***MAJOR PROJECT APPLICATION MP06_0101 MOD & MP11_0093
PEMULWUY MIXED USE DEVELOPMENT, REDFERN***

**MAJOR PROJECT- MP06_0101 MOD & MP11_0093
Pemulwuy Mixed Use Development, Redfern
Preferred Project Report**

RailCorp has also reviewed the Preferred Project Report (PPR) and provides the following comments. RailCorp notes that Page 2 of the PPR report and Page 1 of Appendix 1 makes reference to this future ownership of the bridge. RailCorp advises that any bridge works and future ownership, care and control of the bridge will be subject to final RailCorp approval.

JOB No.	DE/20210
DATE	October 2010
SCALE	A1 @ As Indicated
DWG No.	3DA200 E

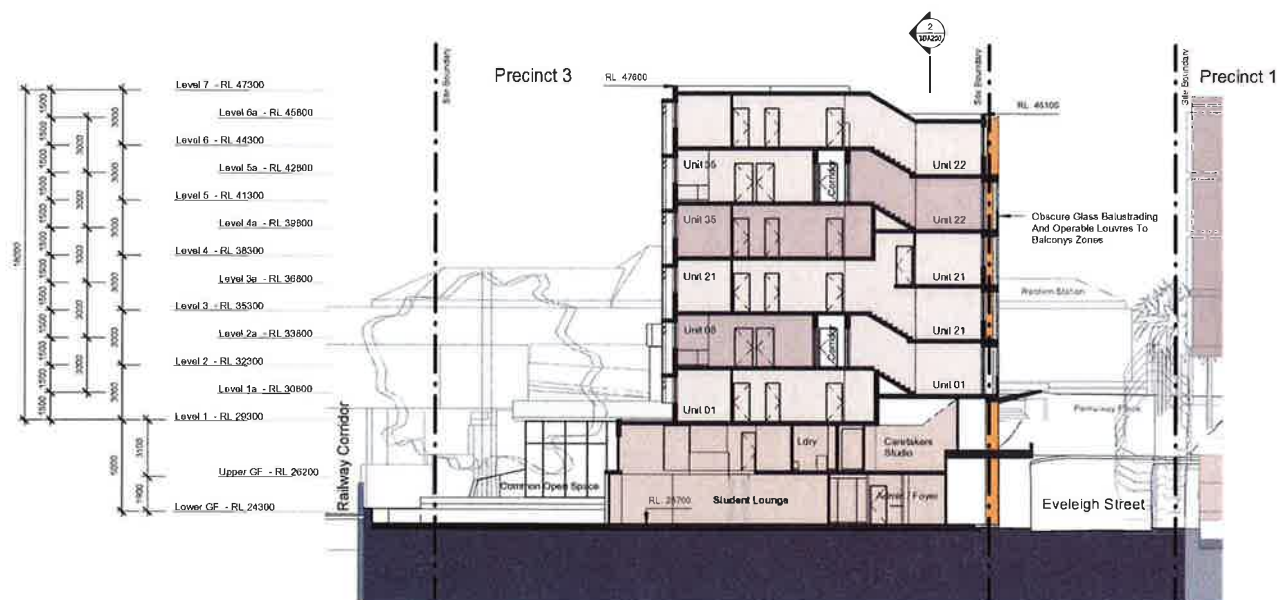
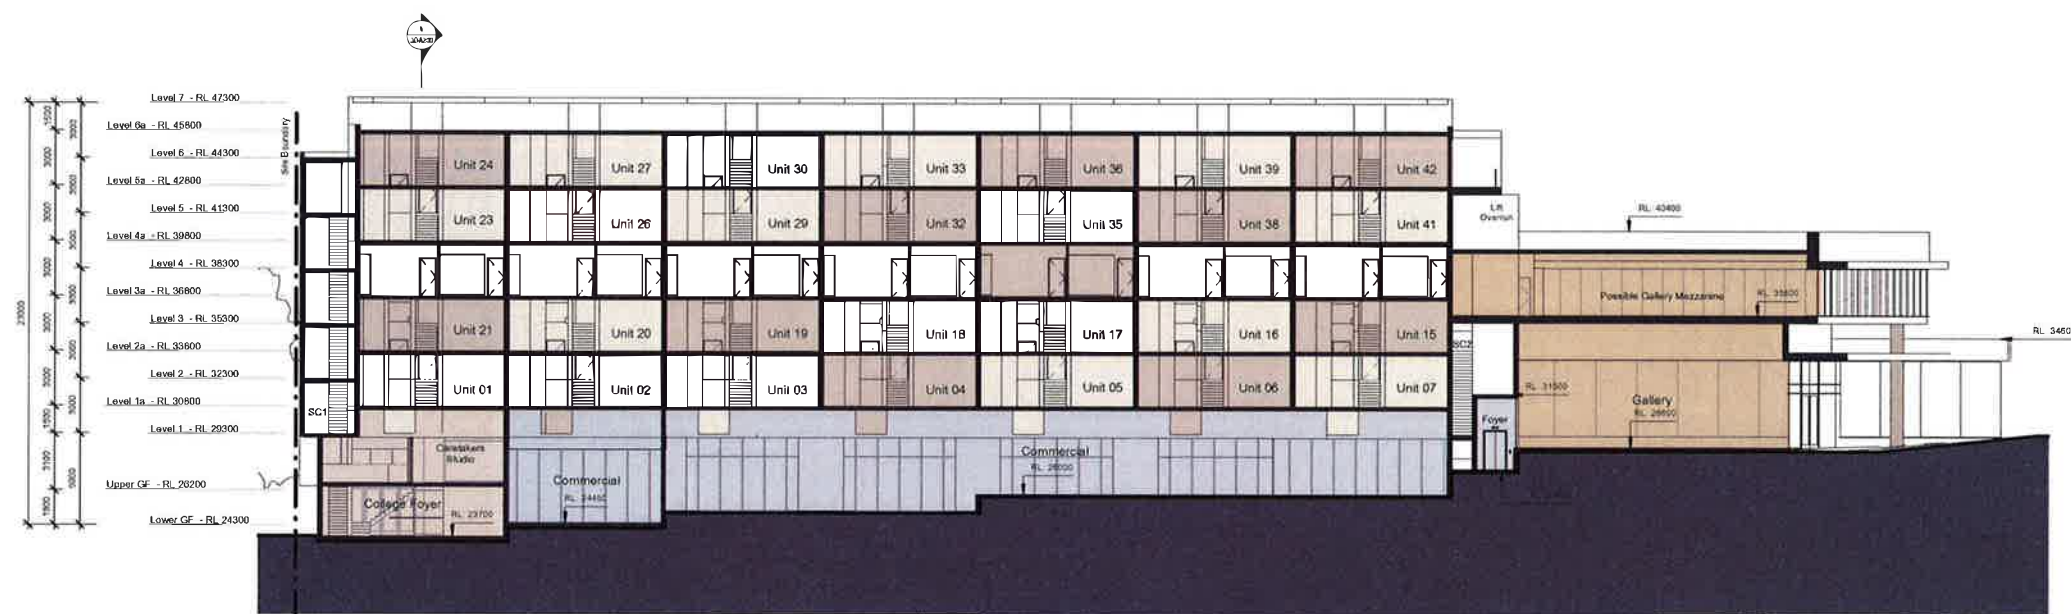
RailCorp also notes that drawing 3DA200(E) now incorporates balconies and roof terraces that were not previously proposed. As such RailCorp needs to ensure that appropriate safety mechanisms are in place to protect the rail corridor and train services from any objects being thrown onto the rail corridor.

- *Given the possible likelihood of objects being dropped or thrown onto the rail corridor from balconies, windows and other external features (eg roof terraces and external fire escapes) from Precinct 3 that are within 20m and face the rail corridor, the Proponent is required to install measures (eg awning windows, louvres, enclosed balconies etc) which prevent the throwing of objects onto the rail corridor.*
